**RE: SITE PLAN – ADMINISTRATIVE DEVELOPMENT FACILITATION TEAM
PR-2024-010691, SP-2025-00031
7520 RAINBOW BLVD NW; LT 11-A BLK 2 PLAT OF LTS 10-A, 11-A, 19-A THRU 22-A BLK
2 UNIT 14 VOLCANO CLIFFS SUBD CONT 2.0312 AC**

Please see responses to DFT comments for **PR-2024-010691, SP-2025-00031**.
Also included are the updated construction drawings to address the comments.

SAFStor Self Storage
3 STORY BUILDING
105,300 SQ. FT.
MAX HEIGHT = 38FT

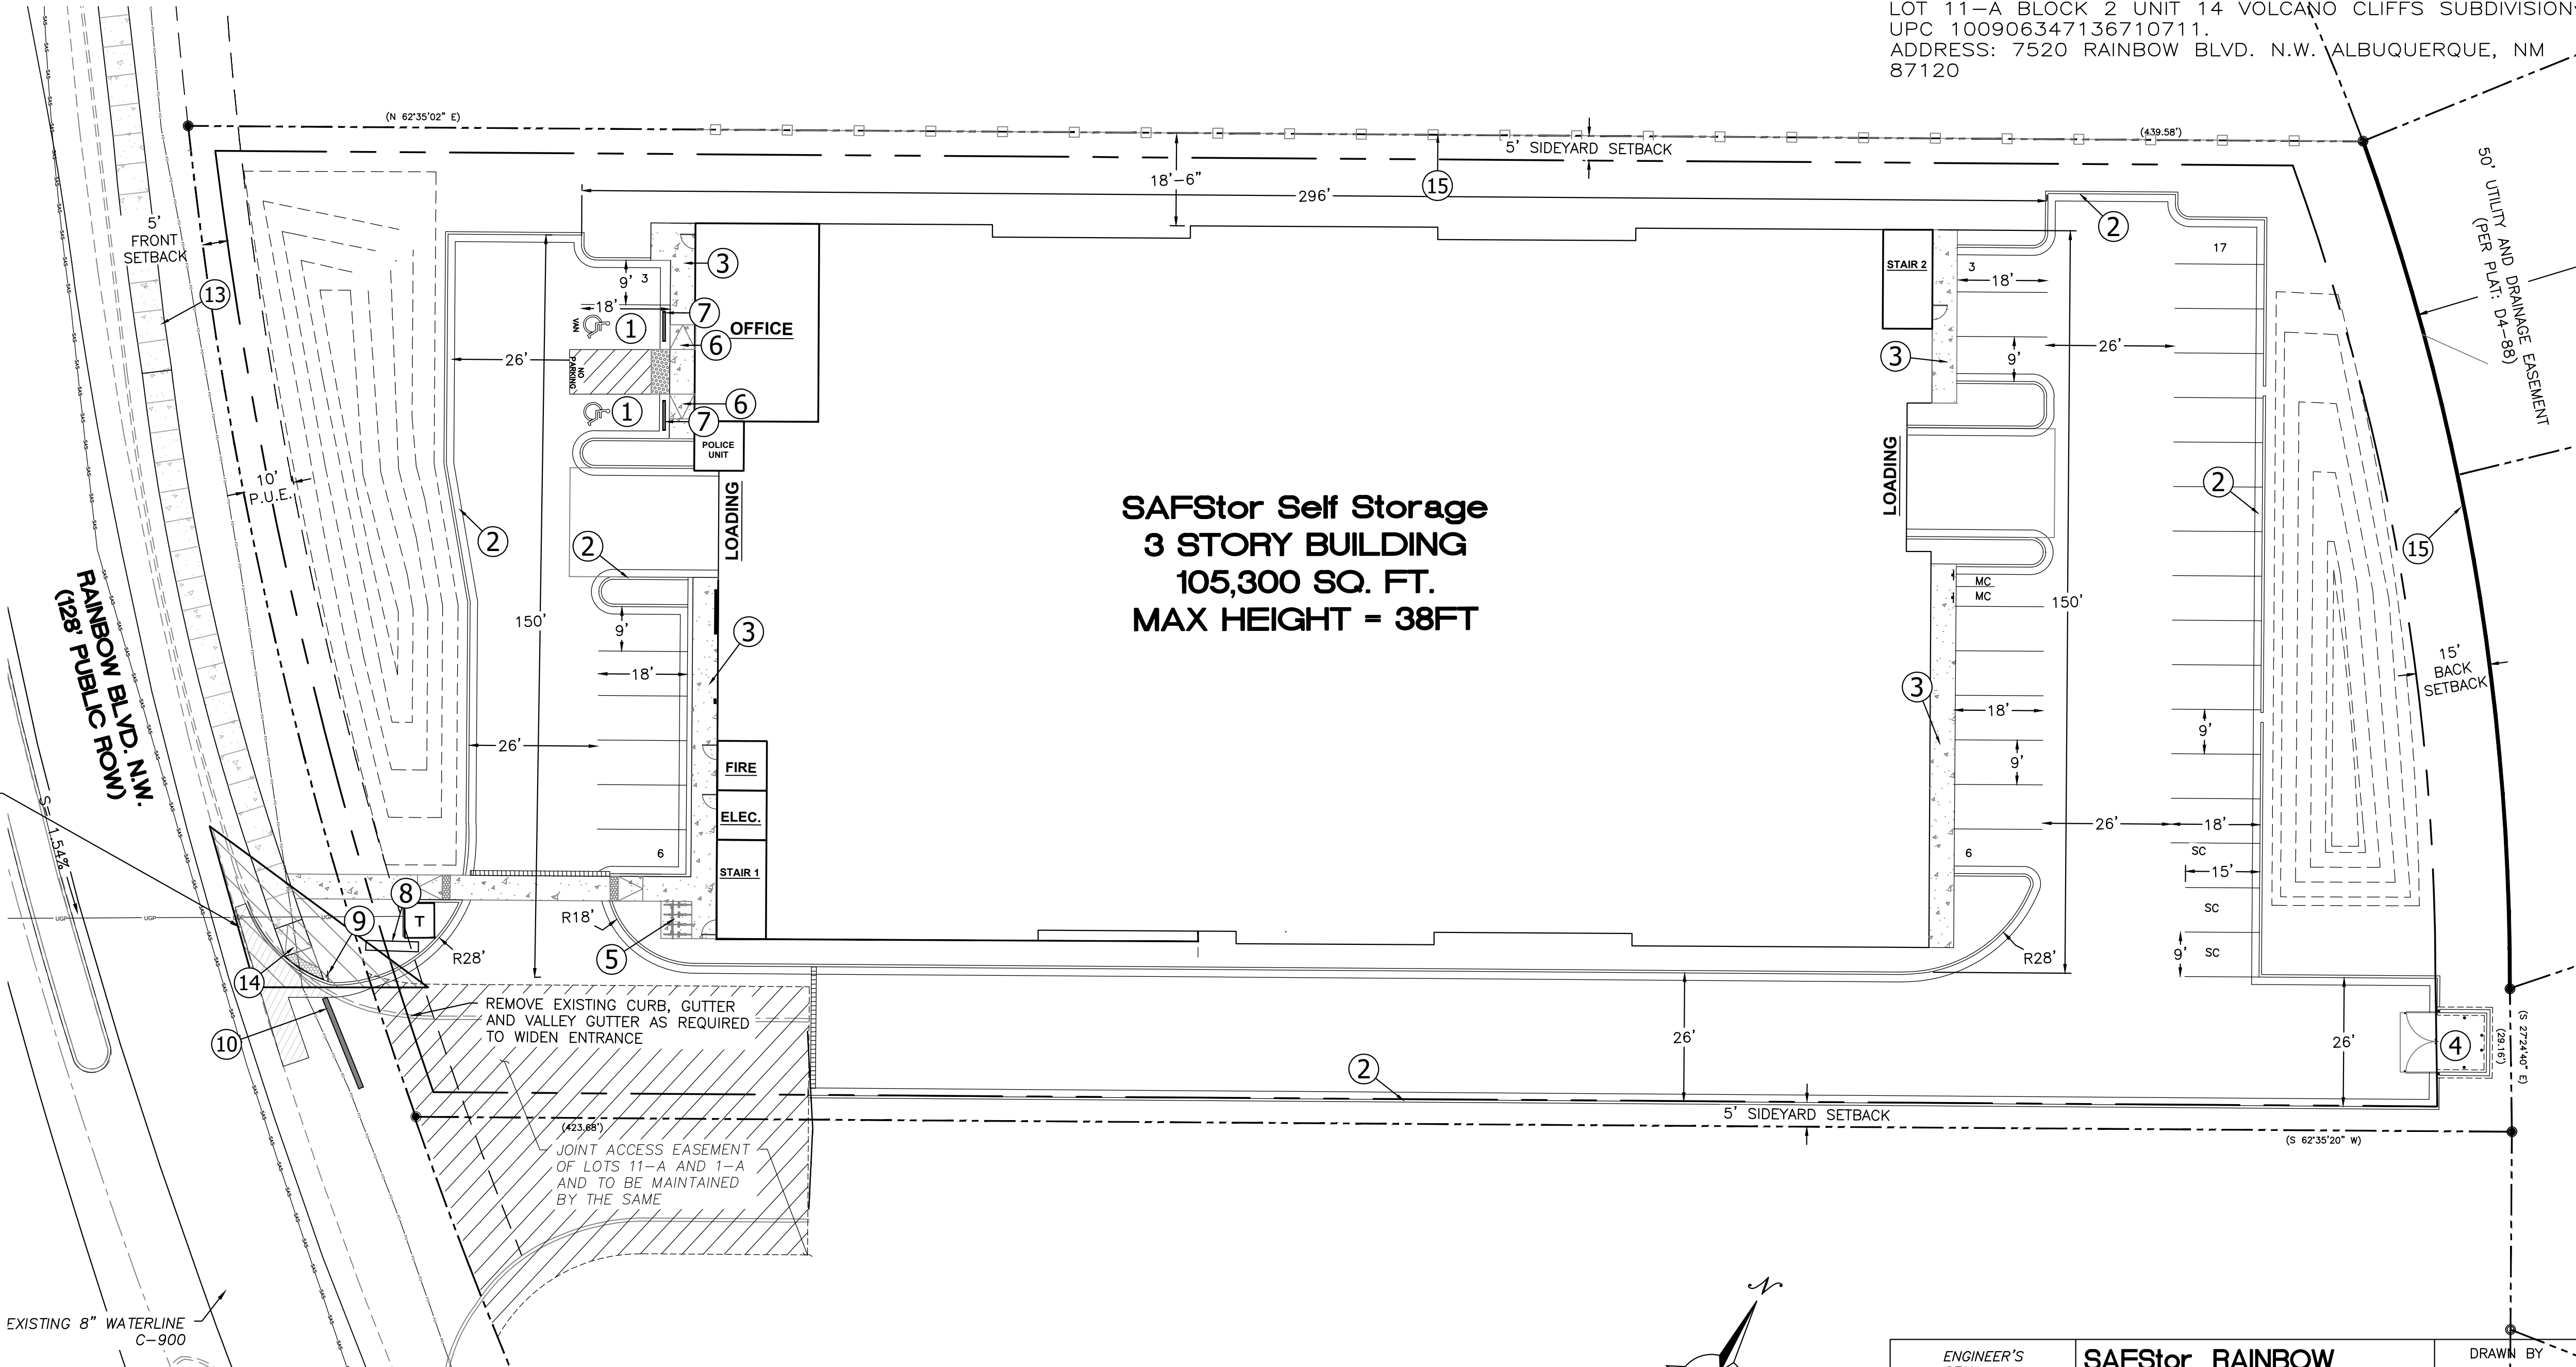
1. Self-Storage requires a conditional use approval in the MX-L zone district as specified in the allowable use table. A conditional use was approved October 02, 2024 and Notice of Decision (NOD) was submitted with this application. The site will also be subject to the requirements of the View Protection overlay Zone (VPO-2). * Plans will demonstrate how these standards are being met.

2. Clarify the Development/Dimensional standards per section 5-1-D, table 5-1-2 and section 3-6(E) Northwest Mesa Escarpment – (VPO-2) height standards.

- a. Rainbow Blvd. is a Principal Arterial Street and requires 6' sidewalk width a 5' to 6' landscape buffer. Please provide a dimension of sidewalks and buffers along the frontage. All work in the ROW needs to be placed on an infrastructure list and done

through City work order. *Verification of standards per Transportation. *Clarify if dedication of right of way is needed for either trail or sidewalk.

RESPONSE: Refer to SP, dimensions abide by the View Protection Overlay Zone (VPO-2)

RESPONSE: Refer to SP, dimensions abide by the Northwest Mesa Escarpment – (VPO-2) height standards. The site is not located within the Sub-VPO2 section.

RESPONSE: Refer to SP dimensions

DRAWING NO: **LS-10'**

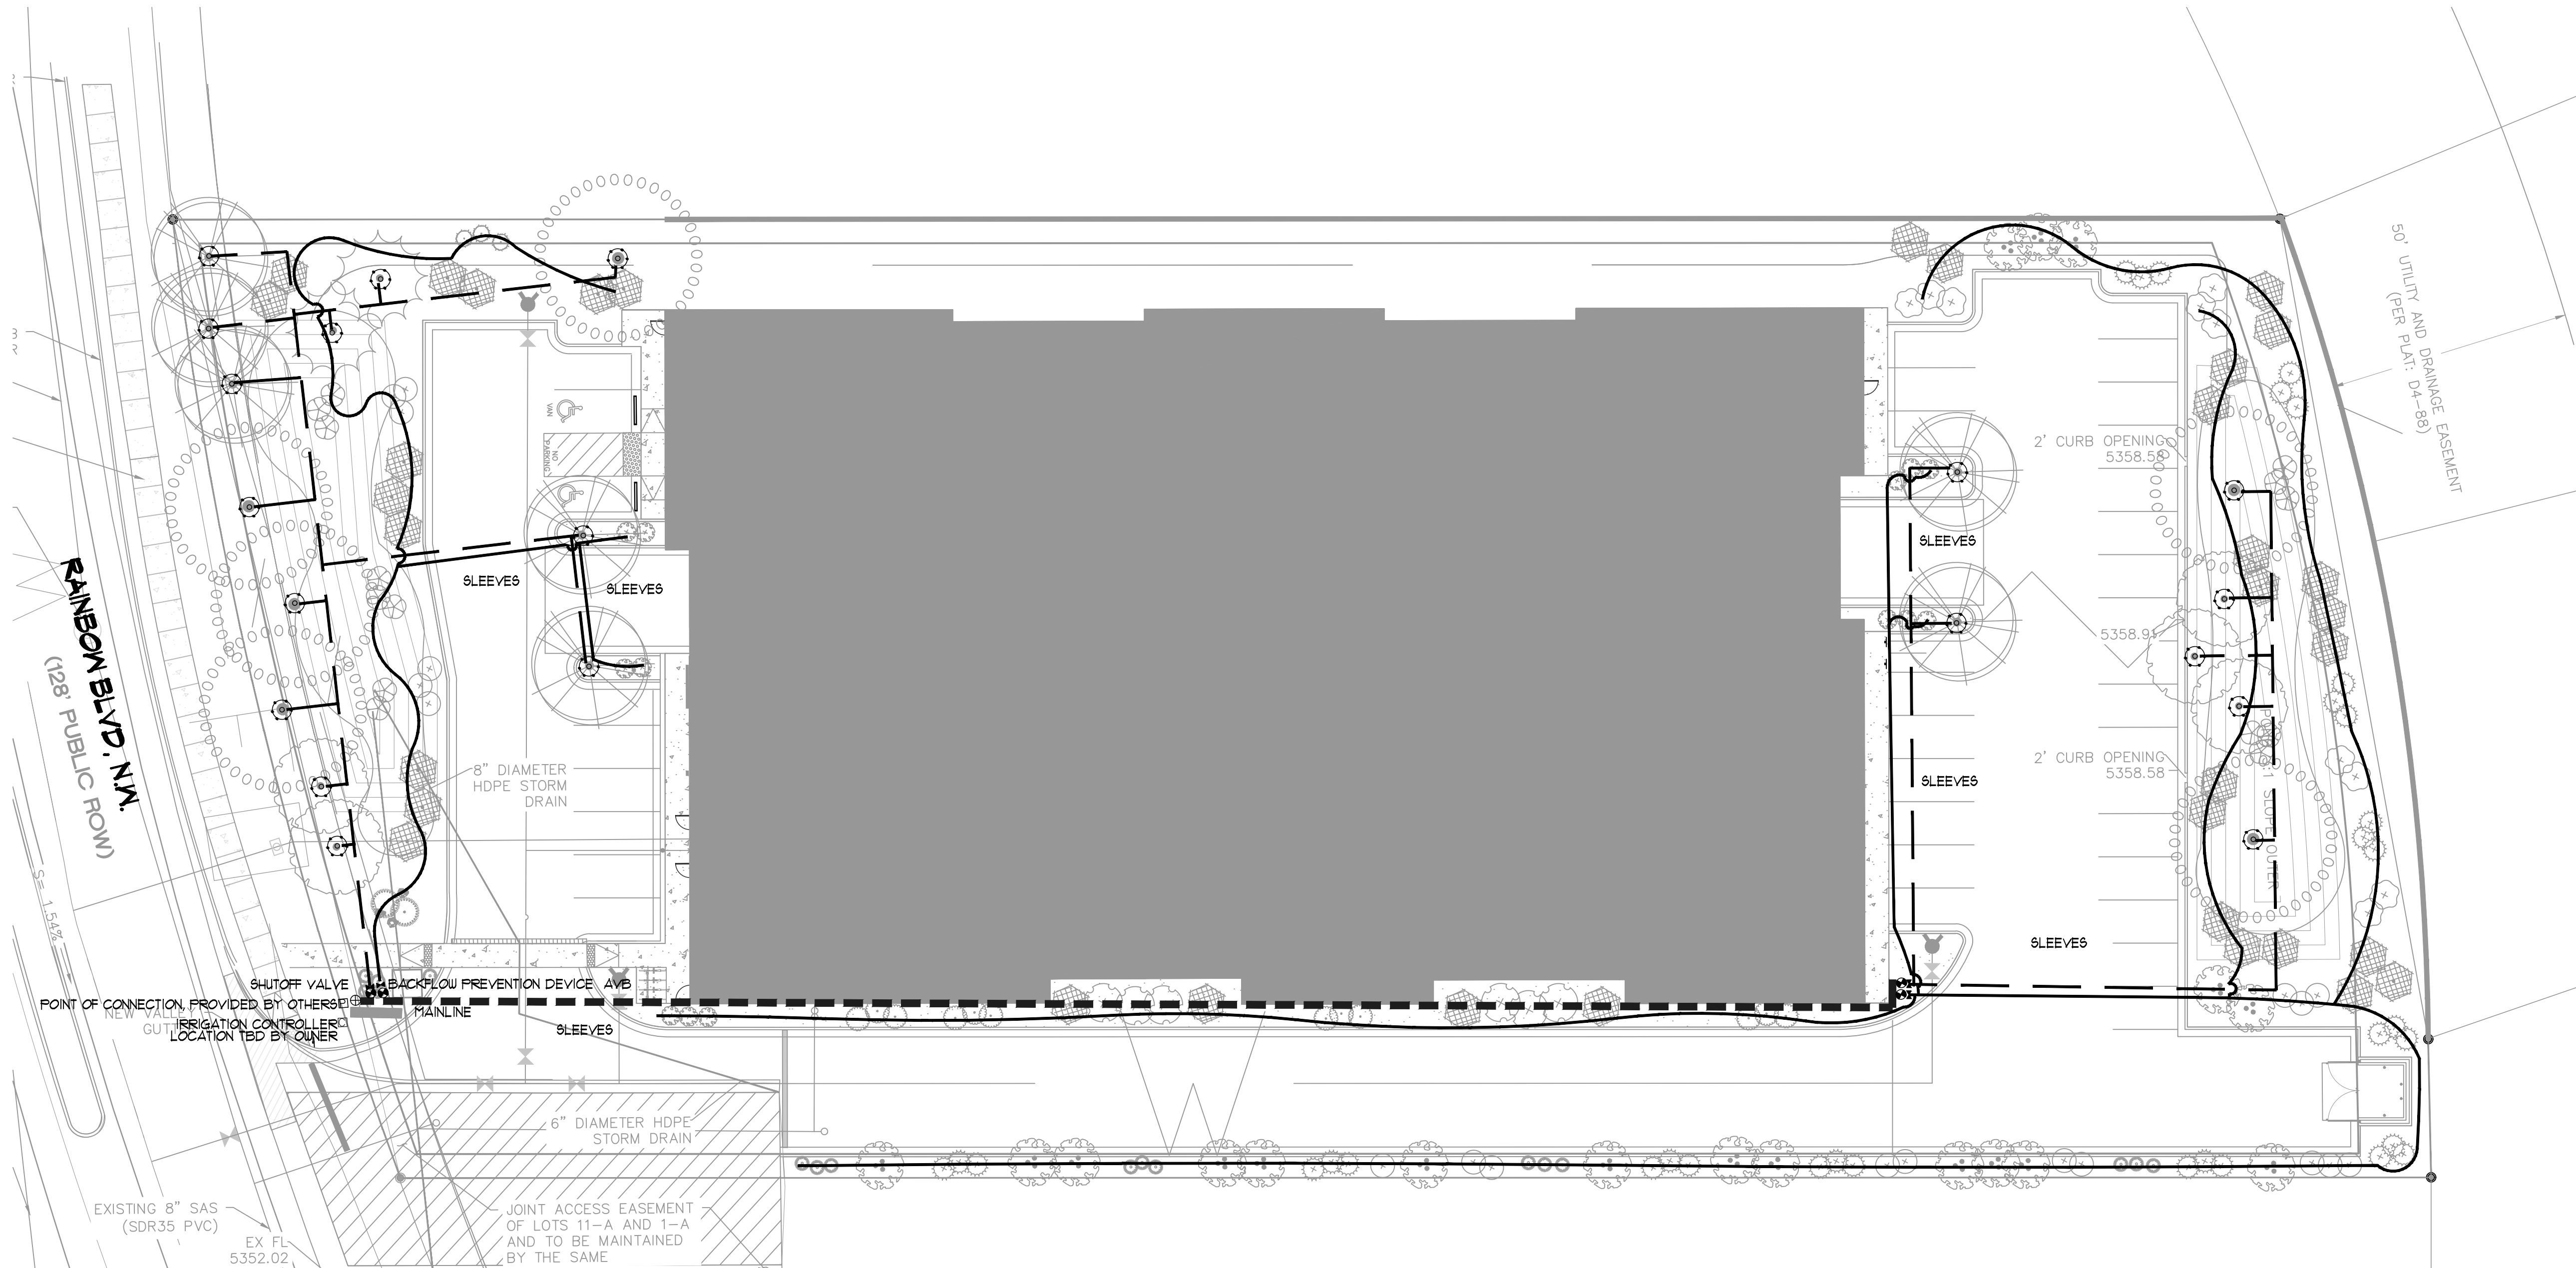
2. Detention ponding areas must comply with Specification 1013 of the City of Albuquerque.

RESPONSE: Acknowledged. See LS-101

FIRE 1
PLAN

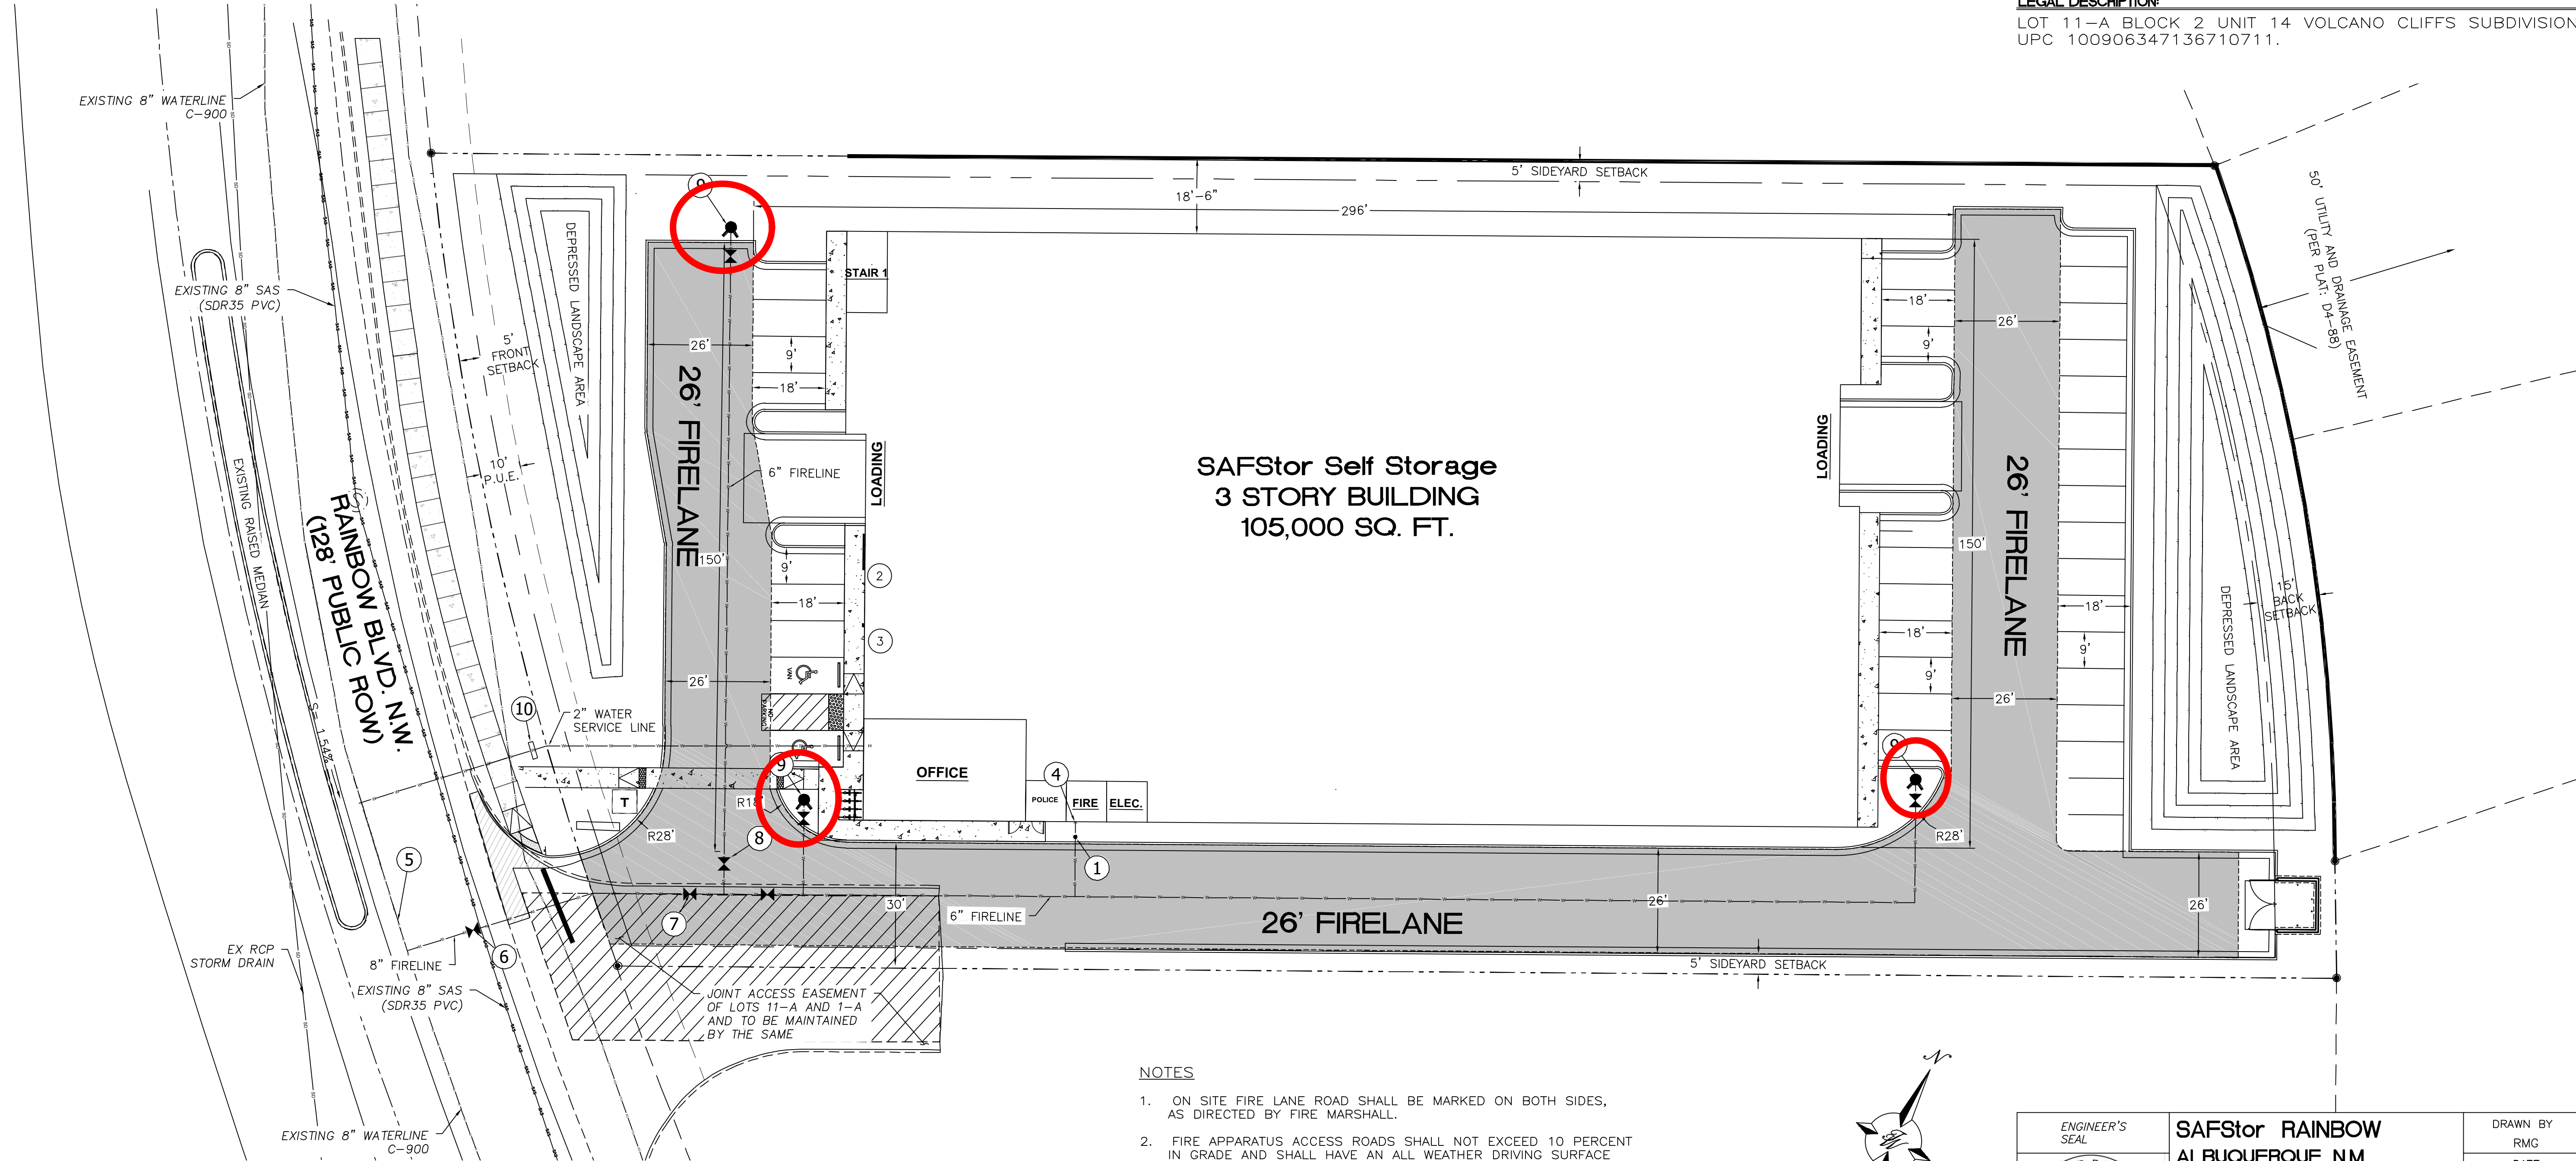
2. Please label the portion of public fire line within the right-of-way as “public” and note that it will be constructed with a work order or connection permit (as applies) as well as any other connections to the public water and/or sanitary sewer systems.

RESPONSE: This has been labeled
